CITY OF ALBUQUERQUE

April 6, 2016

Re: Shopping Center
1220 Eubank NE
Traffic Circulation Layout
Engineer's/Architect's Stamp dated 4-4-16 (J21-D045)

**TRAFFIC CIRCULATION LAYOUT**

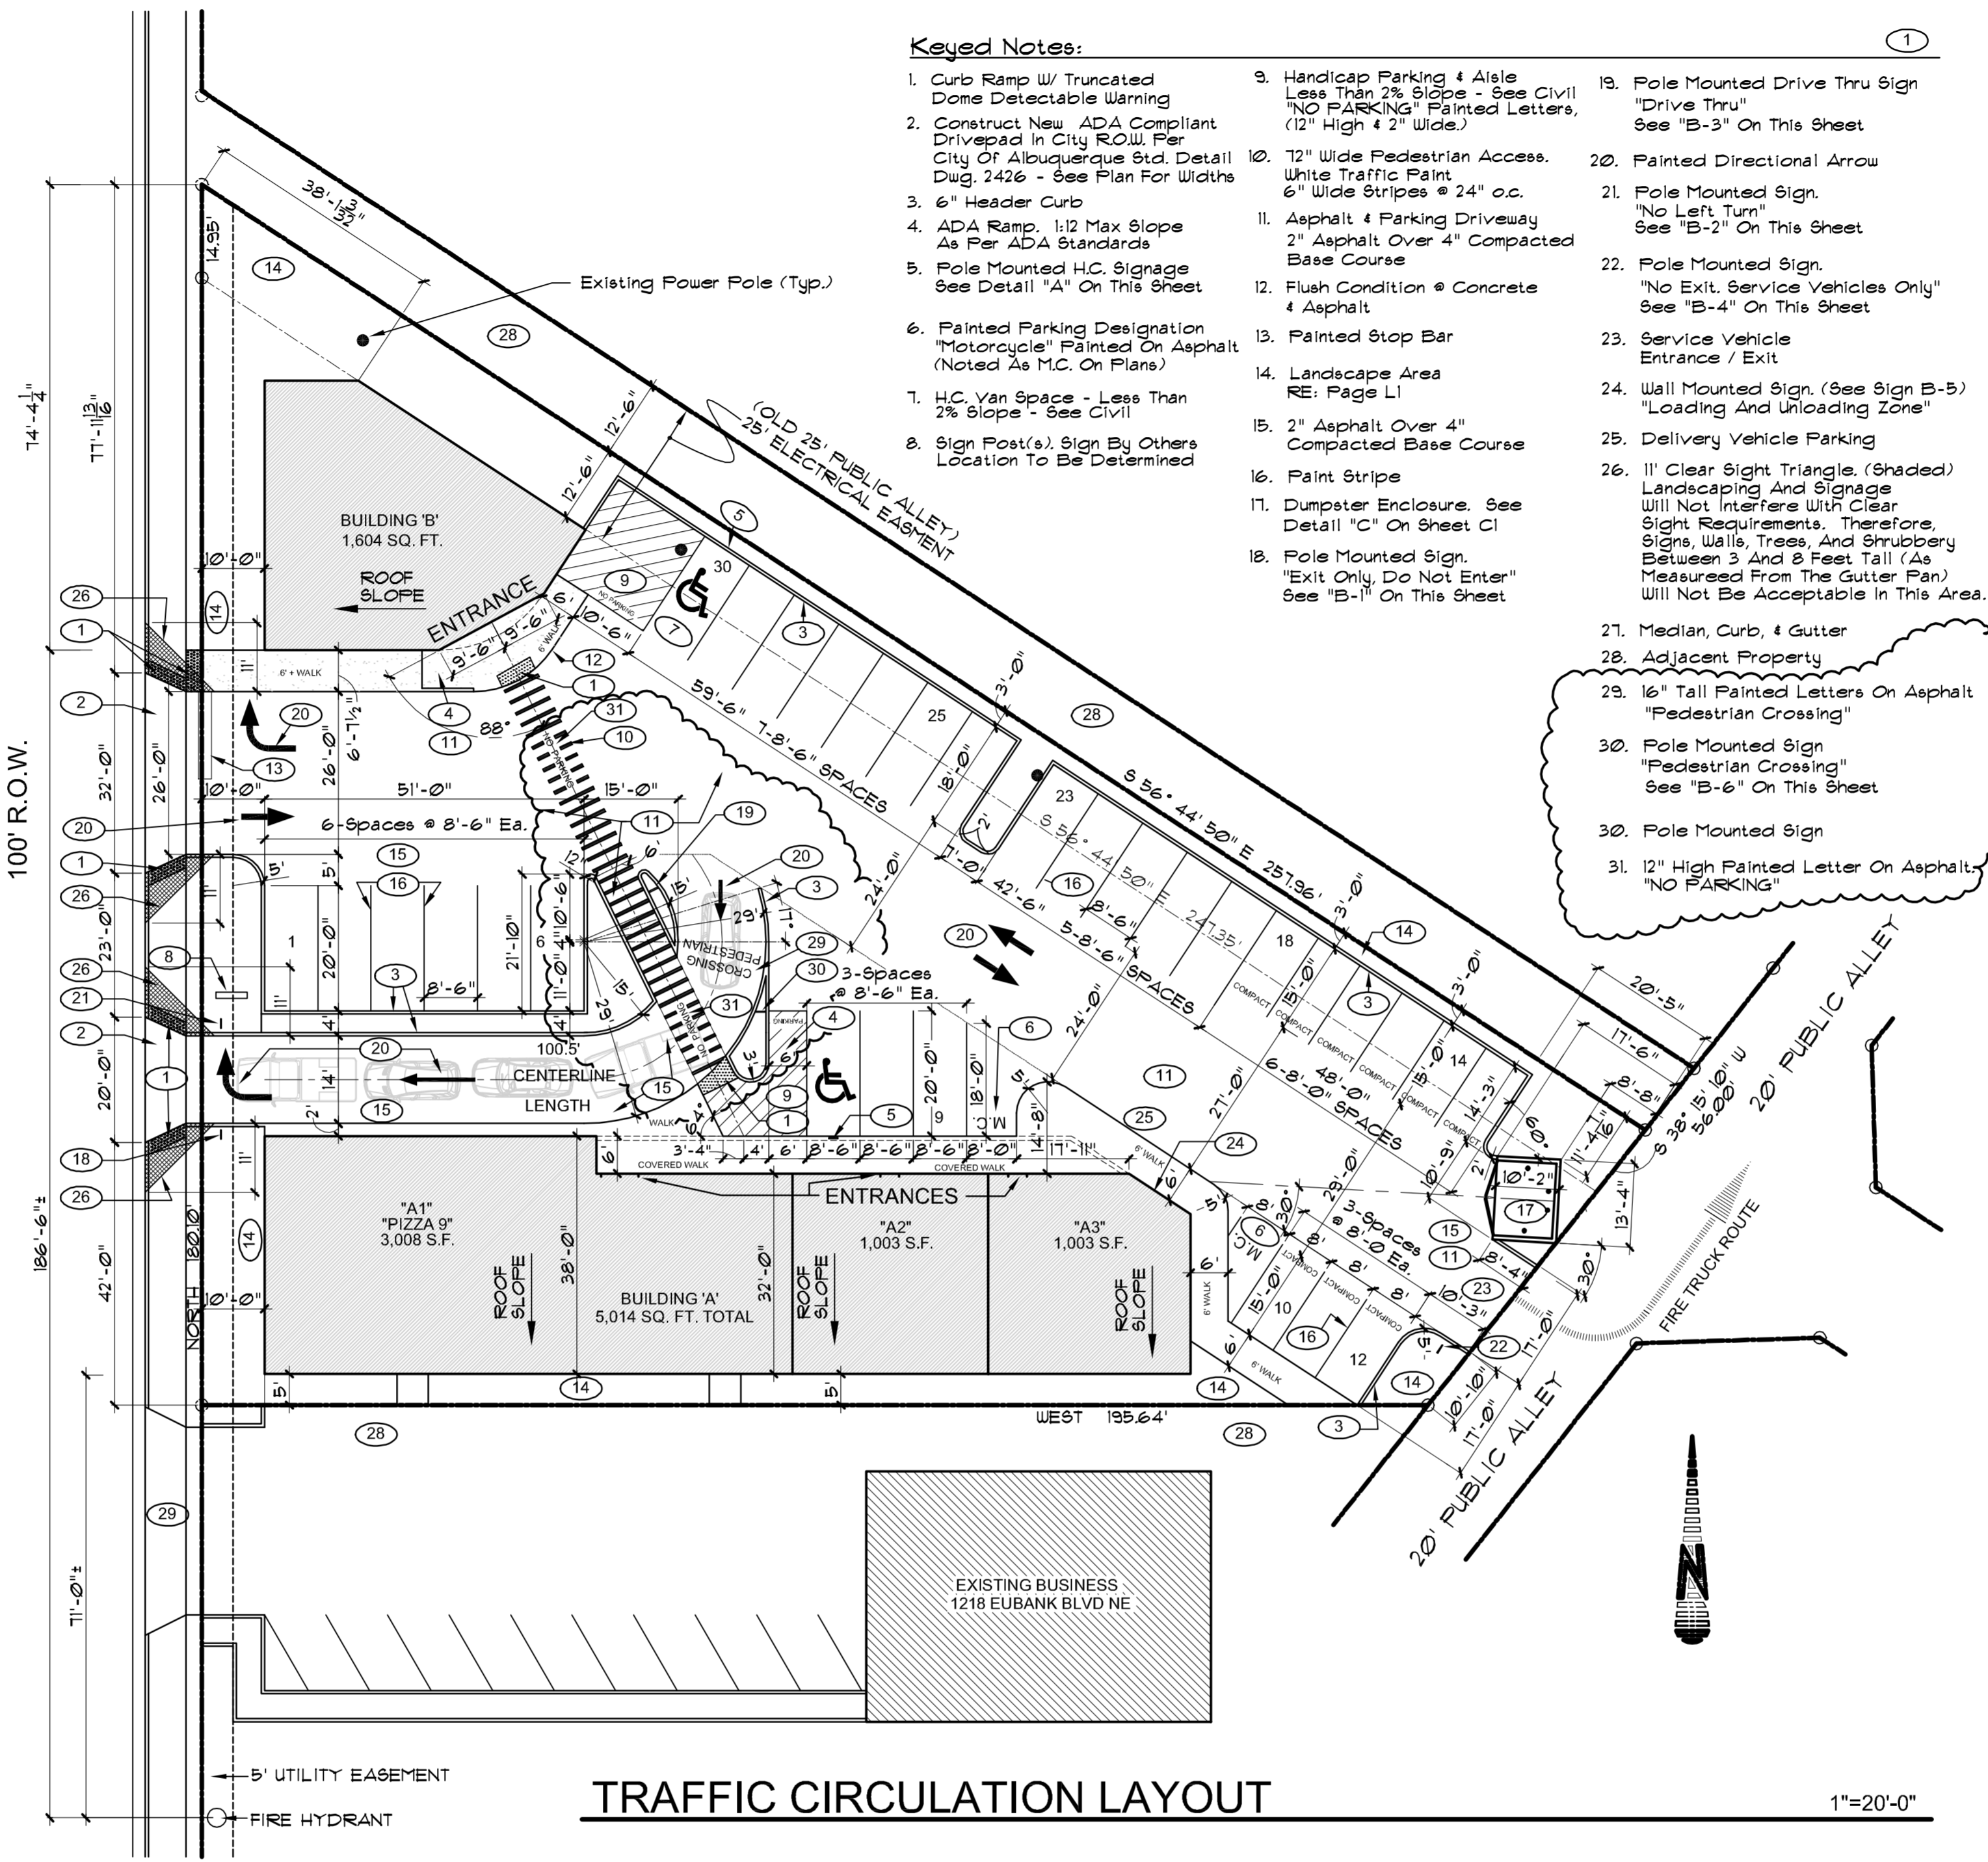
1. Please show a vicinity map showing the location of the development in relation to streets and well known landmarks.
2. List the number of parking spaces required by the zoning code as well as the proposed number of parking spaces.

3. Clarify the extents of the current phase.
4. Please detail the queuing length and show traffic flow directional arrows and signage for Drive-Thru.
5. Please identify all existing buildings, doors, structures, sidewalks, curbs, drive pads, wall and anything that influences the parking and circulation on the site.

6. Identify all existing access easements and rights of way width dimensions.
7. Identify the right of way width, medians, curb cuts, and street widths on Eubank Blvd. and the private alley to the east of the proposed project.

8. Please list the width and length for all existing and proposed parking spaces.
9. The handicap accessible spaces must be a minimum of 8.5 ft. in width.

10. The handicap accessible spaces must include an 8 ft. wide van access aisle; all other aisles should be 5 ft. in width.
11. The ADA accessible parking sign must have the required language per 66-7-352.4C NMSA 1978 **"Violators Are Subject to a Fine and/or Towing."** Please call out detail and location of HC signs.

12. The ADA access aisles shall have the words **"NO PARKING"** in capital letters, each of which shall be at least one foot high and at least two inches wide,

placed at the rear of the parking space so as to be close to where an adjacent vehicle's rear tire would be placed. (66-1-4.1.B NMSA 1978)

13. Show all drive aisle widths and radii.
14. Per DPM, a 6 ft. wide ADA accessible pedestrian pathway is required from the public sidewalk to the building entrances. Please clearly show this pathway and provide details from Eubank Blvd.

15. Per DPM, a 6 ft. wide ADA accessible pedestrian pathway is required from the HC parking stall access aisles to the building entrances. Please clearly show this pathway and provide details. Please clearly show this detail for each building.

16. Truncated domes will be required at all public drive pad entrances/exits. Please show this detail.
17. Design delivery vehicle route needs to be shown.

18. Service vehicle and/or refuse vehicle maneuvering must be contained on-site; provide a copy of refuse approval.
19. One-way vehicular paths require pavement directional signage and a posted **"Do Not Enter"** sign at the point of egress. Please show detail and location of posted signs.

20. It is not apparent what type of pavement surface is being proposed. A hard driving surface will be required as part of this proposed project for parking area and drive aisles.

21. Please provide a sight distance exhibit (see the *Development Process Manual, Chapter 23, Section 3*). Please provide a Clear Sight Triangle detail for major streets for the entrances/exits off of Eubank Blvd. See attached definitions from Development Process Manual.

22. Please add the following note to the clear sight triangle: "Landscaping and signage will not interfere with clear sight requirements. Therefore, signs, walls, trees, and shrubbery between 3 and 8 feet tall (as measured from the gutter pan) will not be acceptable in this area."

23. Please include a copy of your shared access agreement with the adjacent property owner.
24. See Chapter 23, Section 6 of the City of Albuquerque *Development Process Manual*, for appropriate drive pad widths. The drive pad entrance/exit at the south east corner to the public alley must be a minimum of 25 ft. wide.

25. Unused curb cuts must be replaced with sidewalk and curb & gutter. A build note must be provided referring to the appropriate City Standard drawing.

26. All broken or cracked sidewalk must be replaced with sidewalk and curb & gutter. A build note must be provided referring to the appropriate City Standard drawing.
